I REFER TO APPLICATION NO 06-028

REGARDS TO PROPOSED GAS LINE TO PASS THROUGH MY
PROPERTY AT MORPETH AS MY TALKING WITH YOUR
LIASION OFFICER PREVIOUS I DID INDICATE TO HIM THE
POSITION SHOWN ON PLAN WAS NOT WHERE I WOULD LIKE
THE PIPE TO BE RATHER SHIFTED NEAR TO FENCE LINE

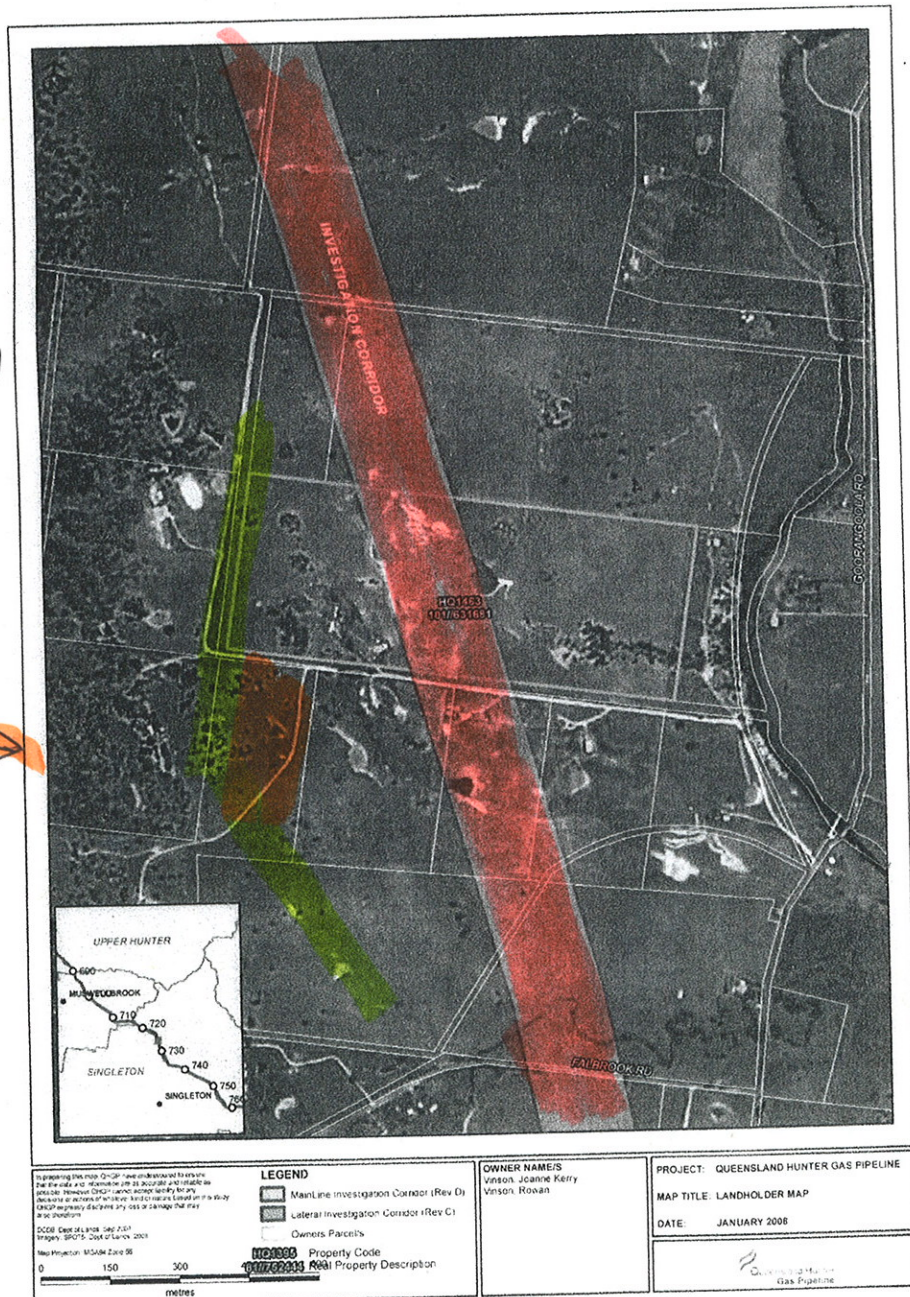
AS THE PIPE DOES TRAVEL THROUGH THE NEXT
DOOR NEIGHBOUR PROPERTY AFTER IT LEAVES ME, I
SUGGESTED IT COULD BE SHIFTED TO NEXT DOOR NEIGHBOUR
THAT WAY ONLY ONE LAND HOLDER TO BE DEALT WITH.
